WEST SUSSEX COUNTY COUNCIL CONSULTATION

TO:	Arun District Council FAO: Zoe Toppin
FROM:	WSCC - Highways Authority
DATE:	16 September 2021
LOCATION:	7 St. Richards Way Bognor Regis PO21 3BD
SUBJECT:	AW/258/21/HH Installation of driveway and extension to drop kerb.
DATE OF SITE VISIT:	n/a
RECOMMENDATION:	Advice
S106 CONTRIBUTION TOTAL:	n/a

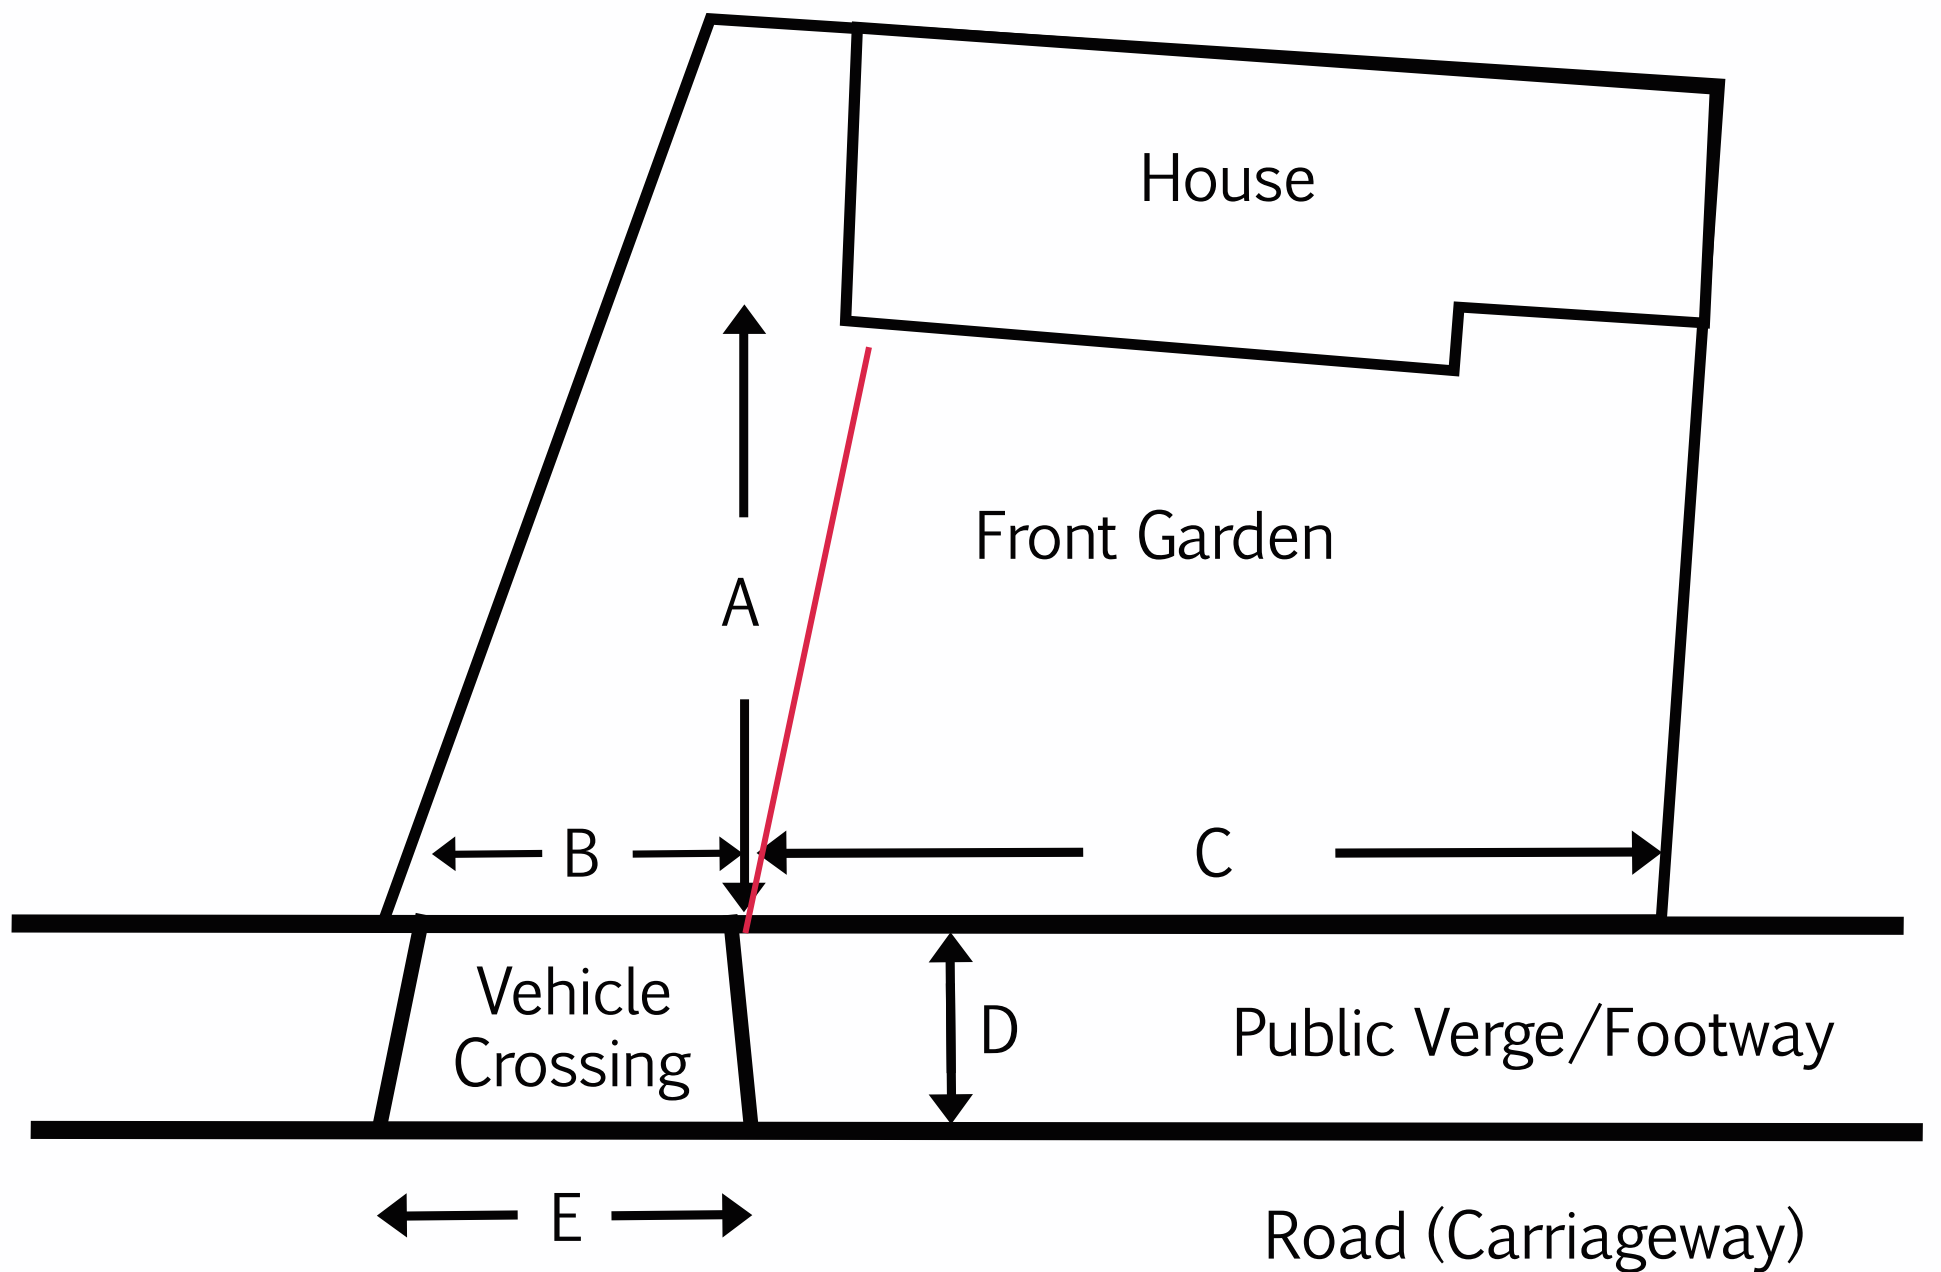
The proposal seeks the installation of driveway and extension to drop kerb at 7 St Richards Way, Aldwick. In principle the application seeks to extend the existing dropped crossing of 5 St Richards Way, Aldwick, which is located at the southern extend of the plot to provide an access point to 7 St Richards Way, Aldwick.

It is noted that 7 St Richards Way, Aldwick already benefits from a dropped crossing access at the northern extent of the plot. This access will be afforded comparable visibility to the existing access arrangements.

While there would be no highway safety concern raised to the proposed the applicant should be aware that the access works must be implemented under licence to a specification obtained from WSCC Highways.

Part of the licence application process looks at if the dwelling is already served with an access point. Crossover licence applications to facilitate a 2nd access point are typically refused in order to preserve all available on street car parking. This is regardless of any planning approval obtained. It is anticipated this will be the case with this particular 2nd access.

The applicant is advised that in addition to obtaining planning permission that they must also obtain formal approval from the highway authority to carry out the site access works on the public highway. The granting of planning permission does not guarantee that a vehicle crossover licence shall be granted. Additional information about the licence application process can be found at the following web page:
